Application by Norfolk Boreas Limited for an Order Granting Development Consent for the Norfolk Boreas Offshore Windfarm Project

Issue Specific Hearing:	Onshore effects including the draft Development Consent Order
Date:	21 January 2020 at 10.00am
Location:	Blackfriars Hall, St Andrew's Plain, Norwich, NR3 1AU

Purpose of the Issue Specific Hearing into Onshore effects including the draft Development Consent Order.

CAWSTON HIGH STREET - INTERVENTION SCHEME  
Scale 1:500

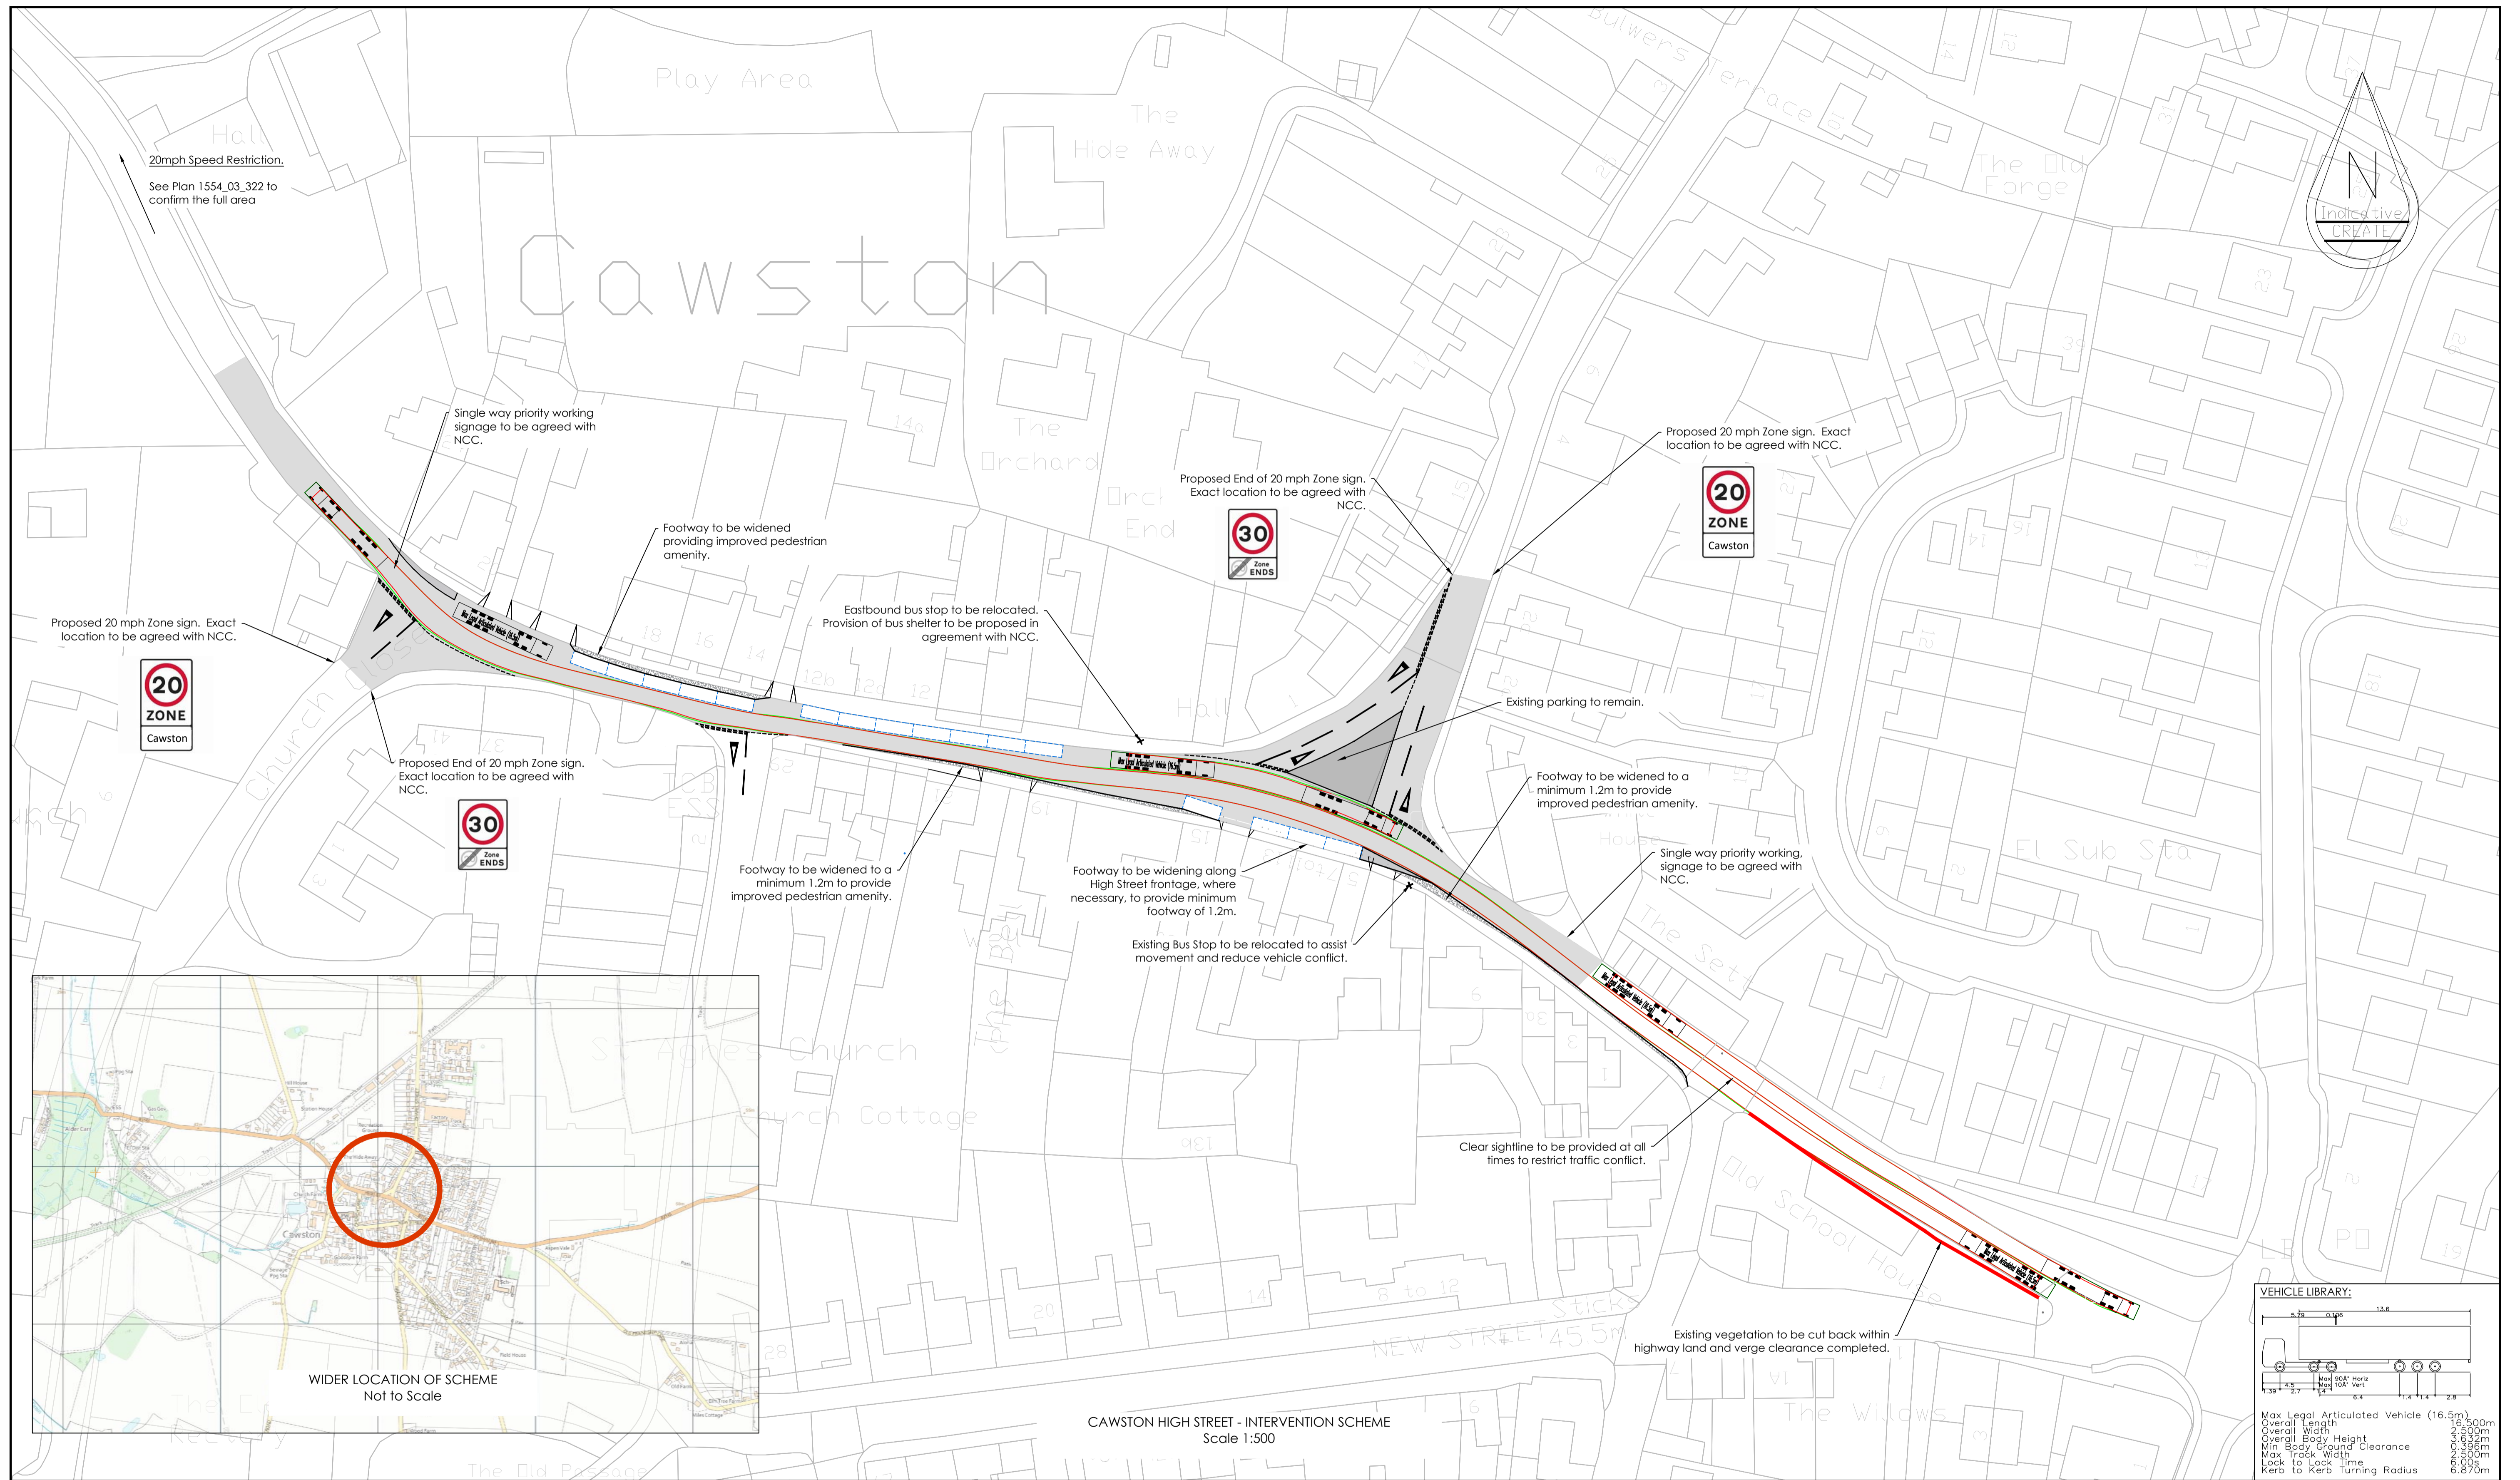
- IV. To examine in detail the Highway Intervention Scheme referred to by the Applicant [REP1-024, Appendix 6] in relation to mitigation of construction traffic impacts of Hornsea Three and cumulative impacts with Norfolk Vanguard and Norfolk Boreas, including road safety issues and footpath widening;

**APPENDIX 3: OS MAP SHOWING CHANGE IN LEVELS VP3 (AGENDA ITEM
4 (a) II)**

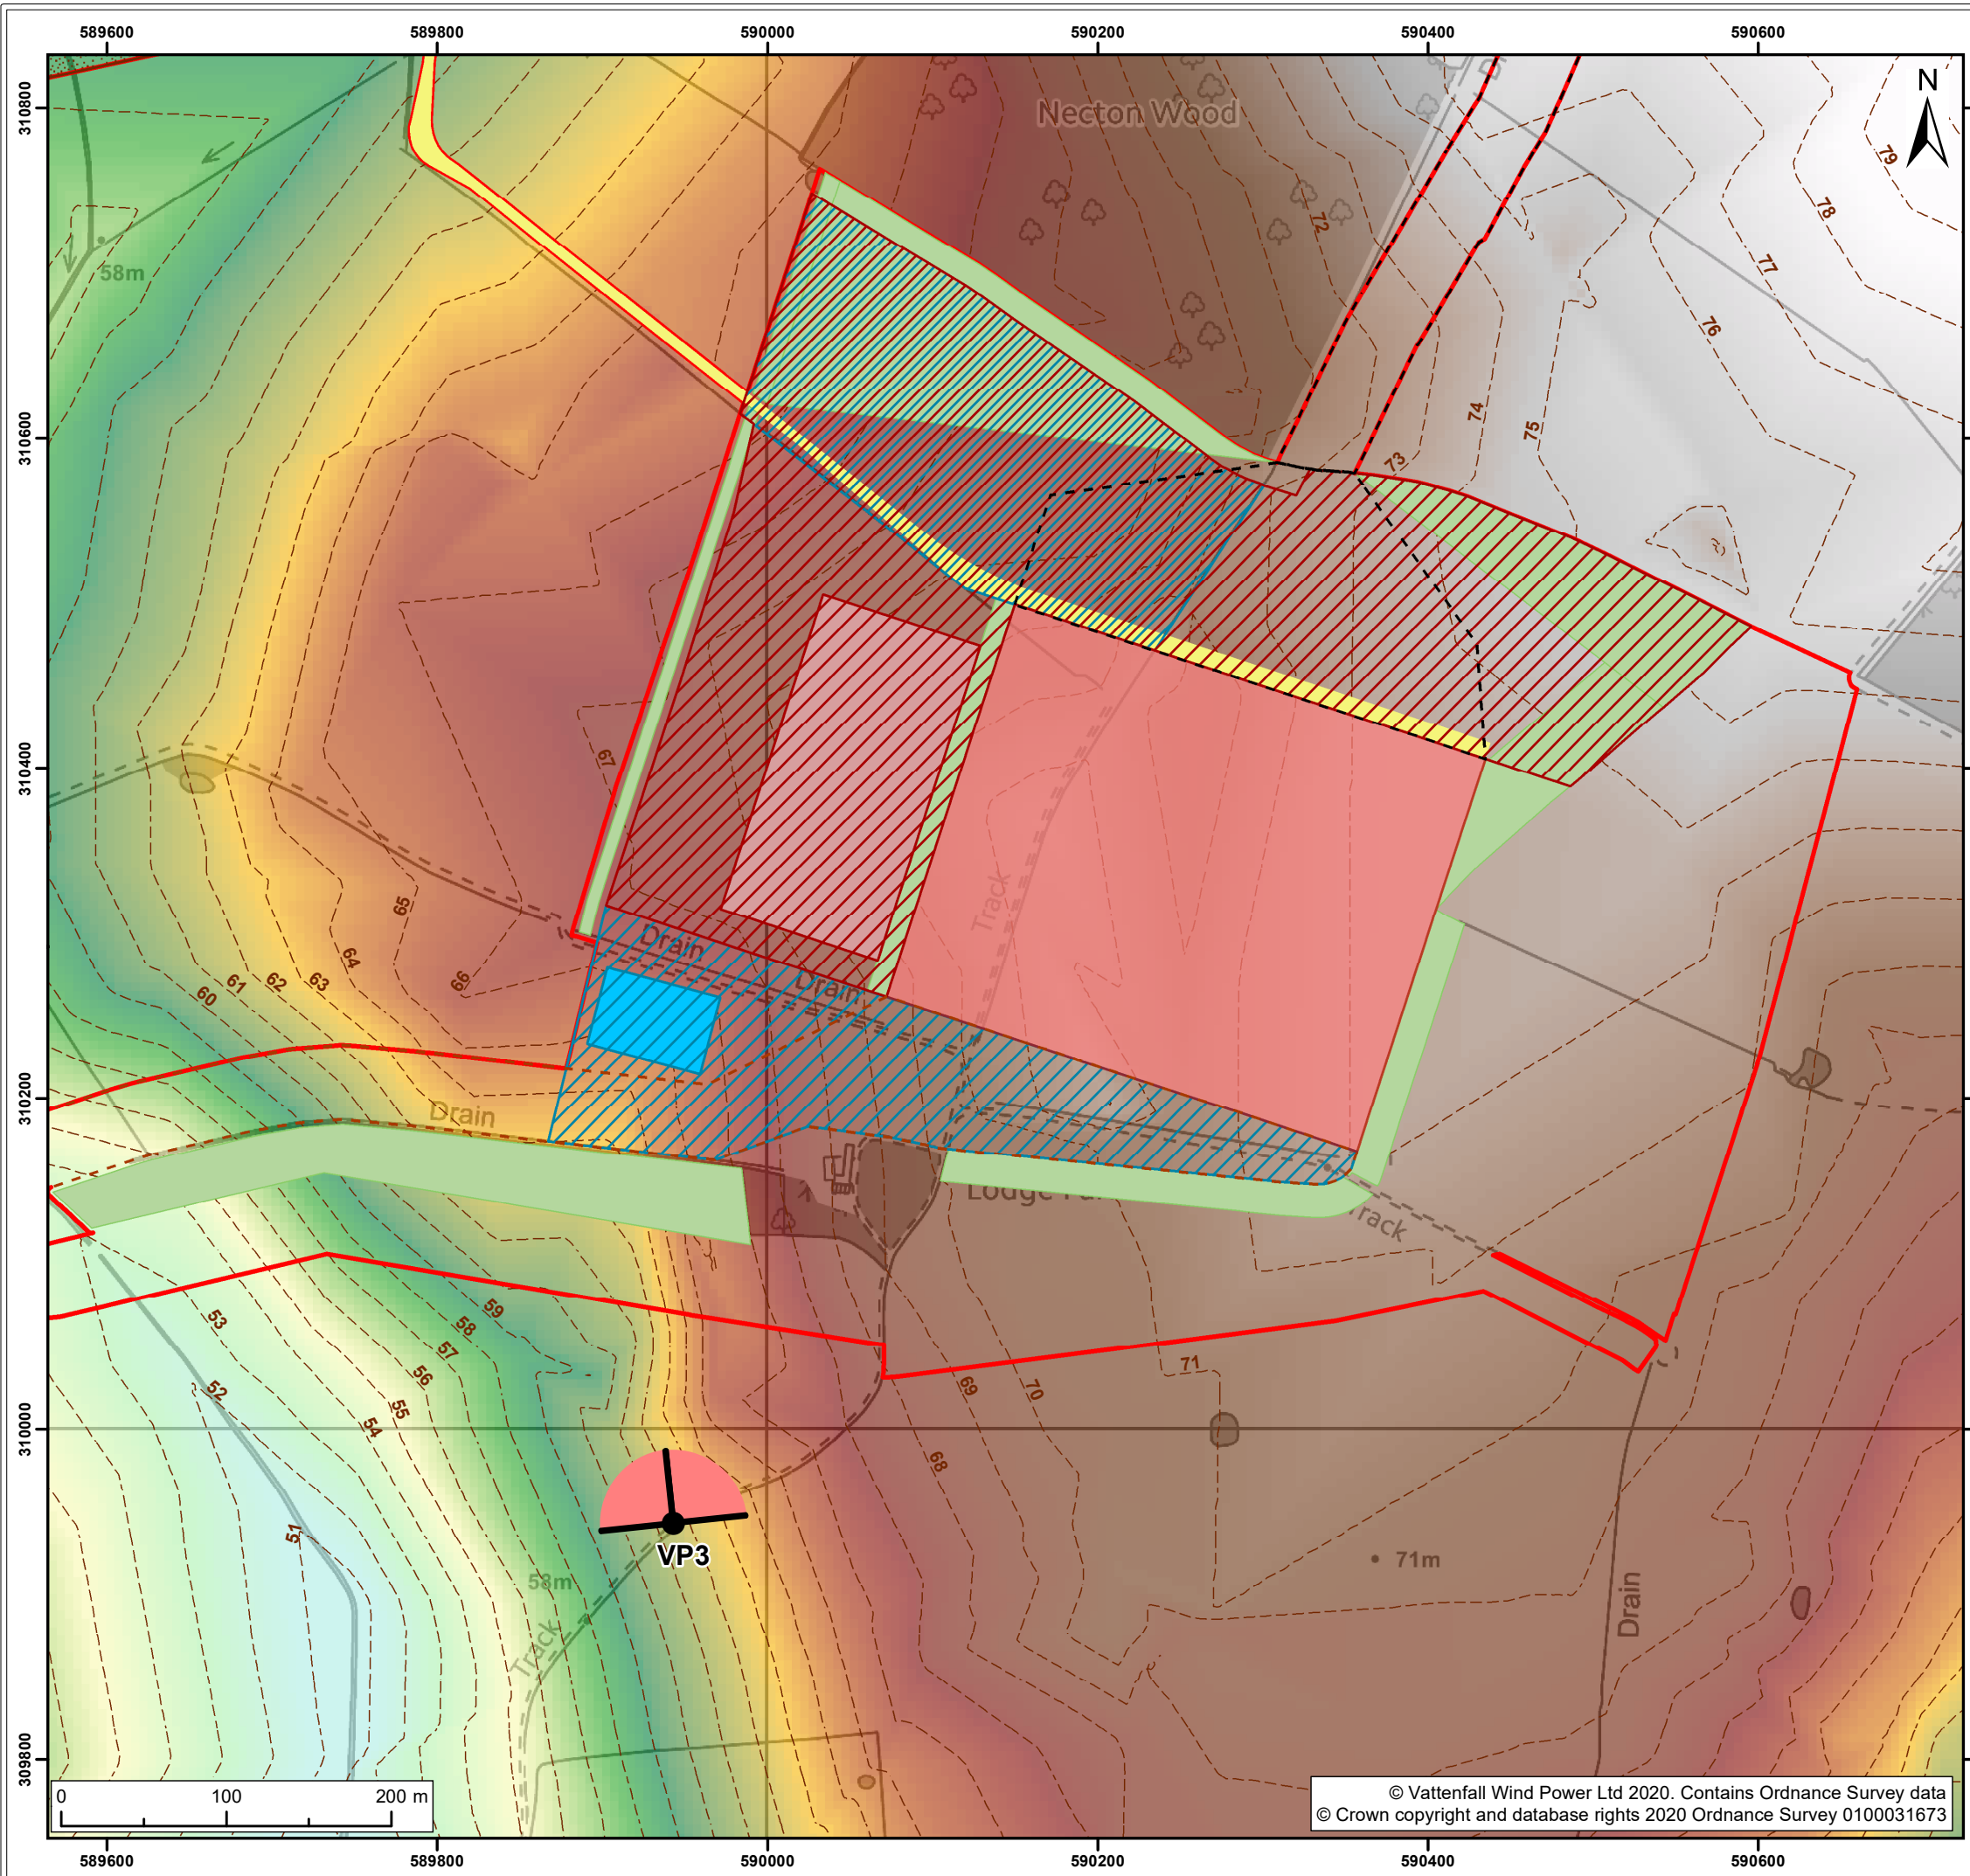
- II. If Mr King or Ms Lockwood is present, to have the differences of opinion regarding the landform in the visualisation for VP3 [APP-511] and/ or [APP-523] explained using the visualisations and an OS map (Applicant to make available on screen) firstly by Mr King/ Ms Lockwood and then by the Applicant [REP3-007].

Relationship of Onshore Plans secured by the DCO

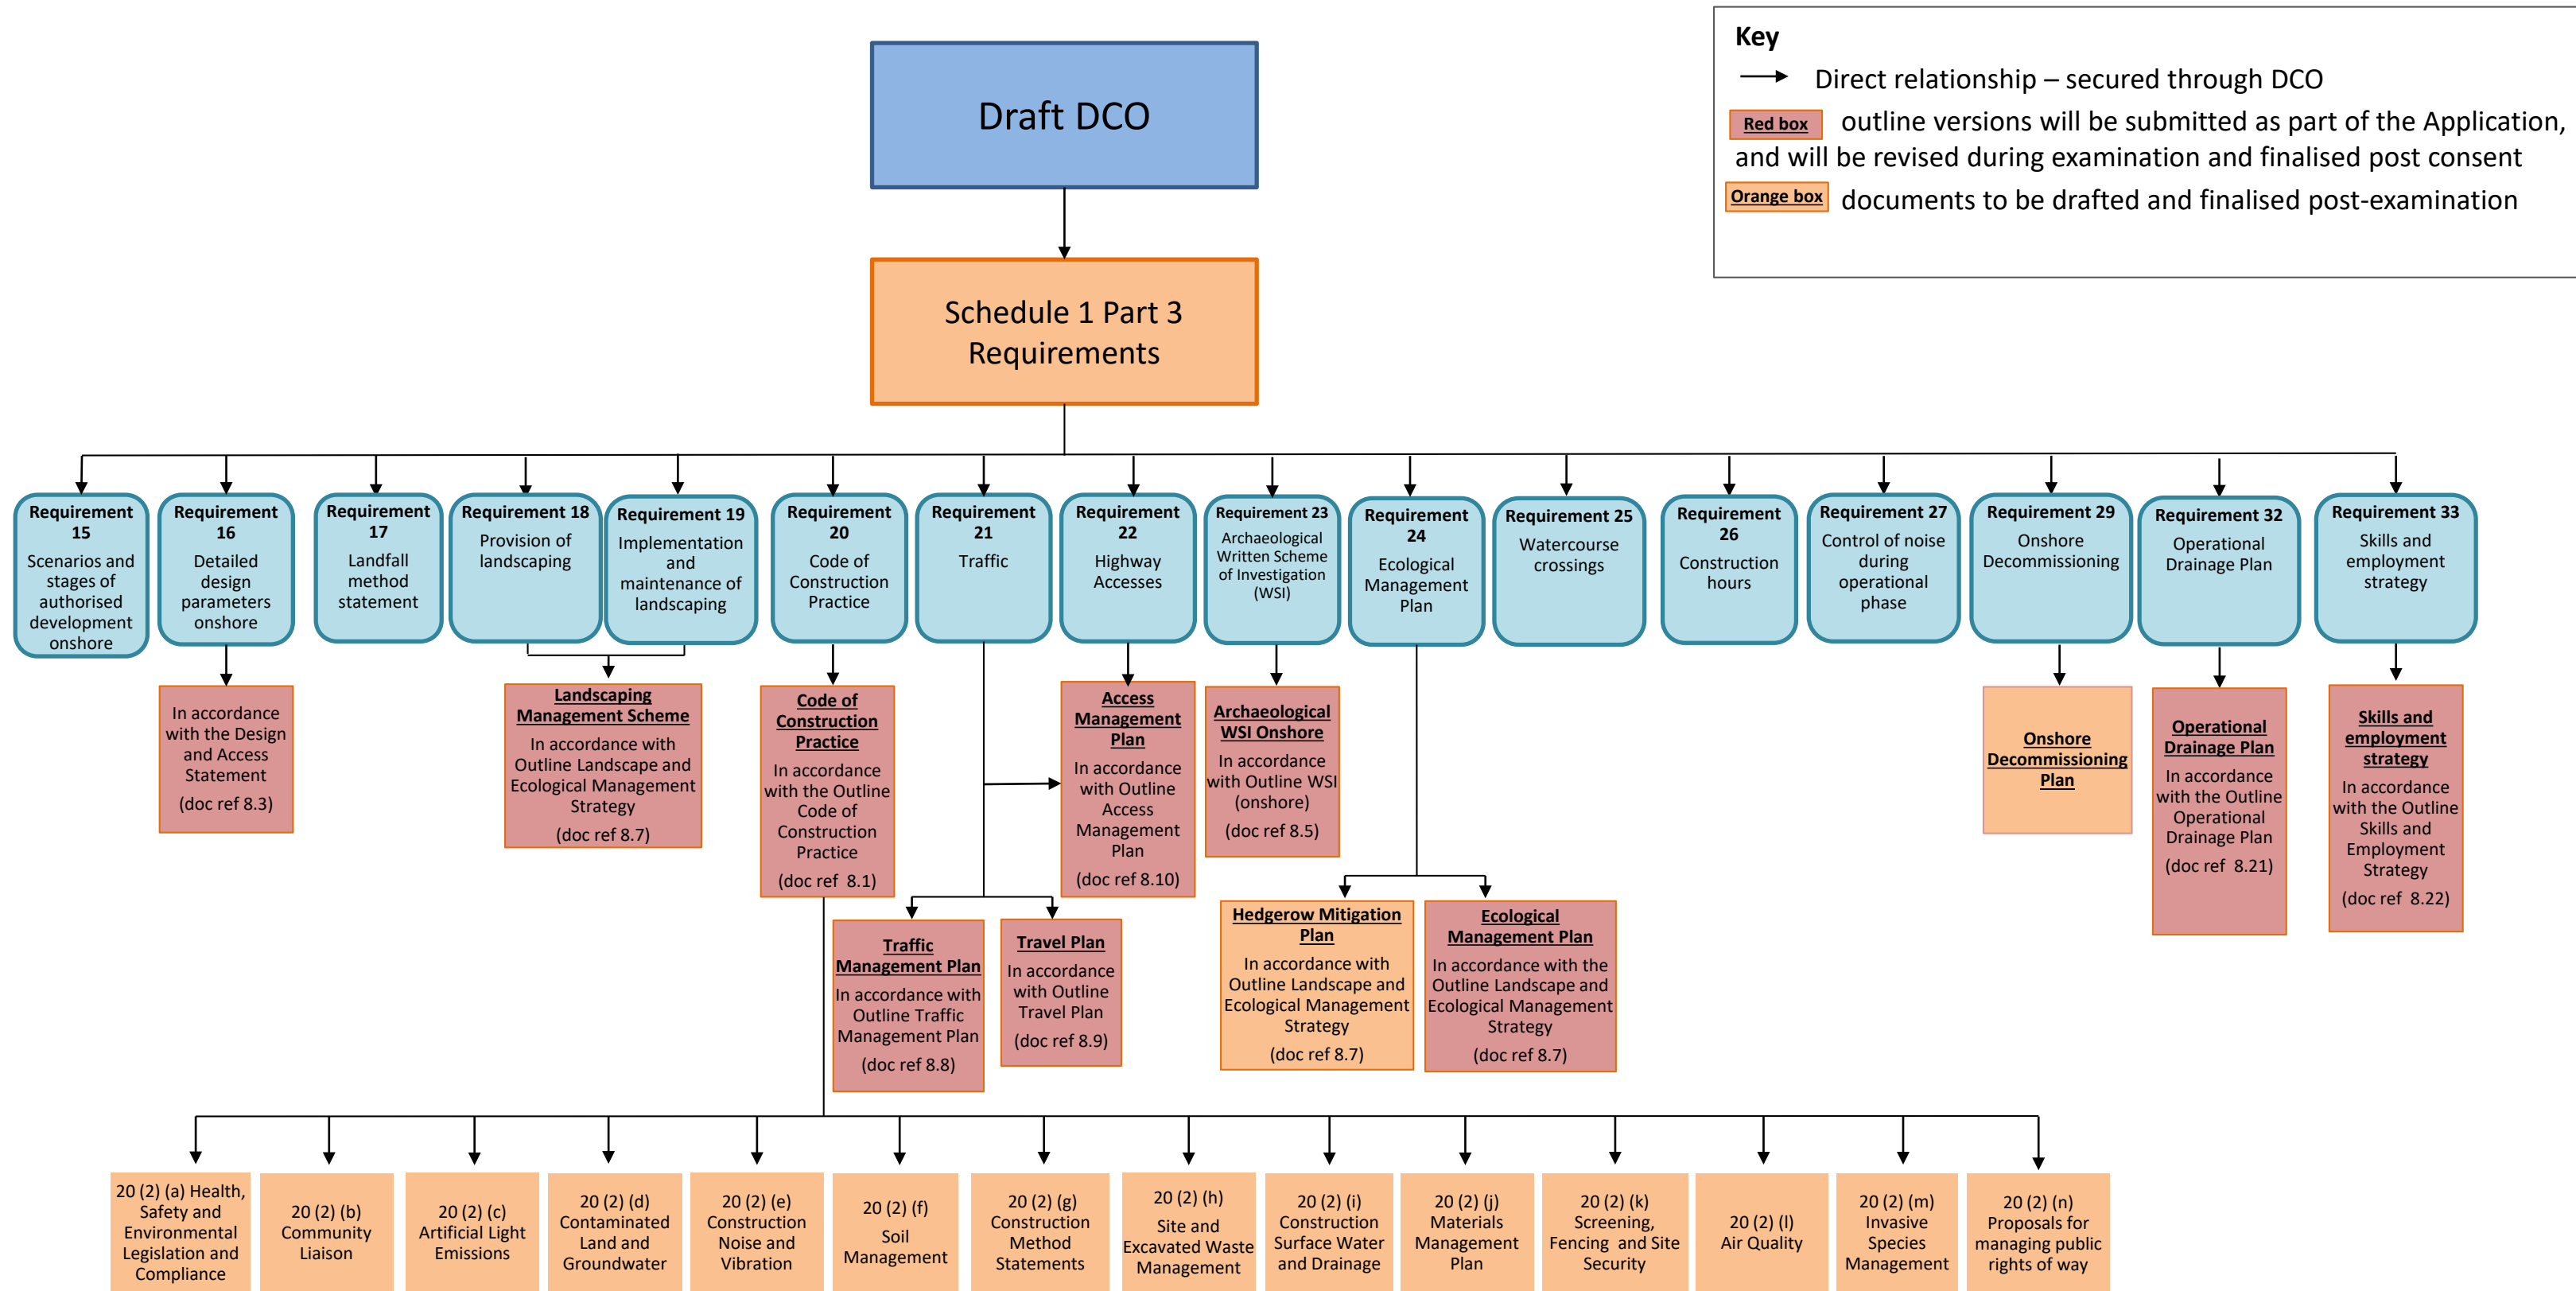
- III. Following updates and responses regarding the dDCO and the OCoCP clarity is required regarding the relationships of the OCoCP with all the other Outline plans and how matters are secured. Other Outline plans are stated as secured as "*Separate requirements outwith the CoCP*". In places the OCoCP covers matters covered by other Outline plans. In places it appears that matters are split between the OCoCP and other Outline plans and therefore across different Requirements. Therefore, there is a power to install/ erect, but it is not compelled to consider in relation to the OCoCP. The Applicant will be requested to talk this through using the Relationship of Onshore Plans secured by the DCO diagram [APP-022, Annex 1]. Views will be sought from post consenting authorities.
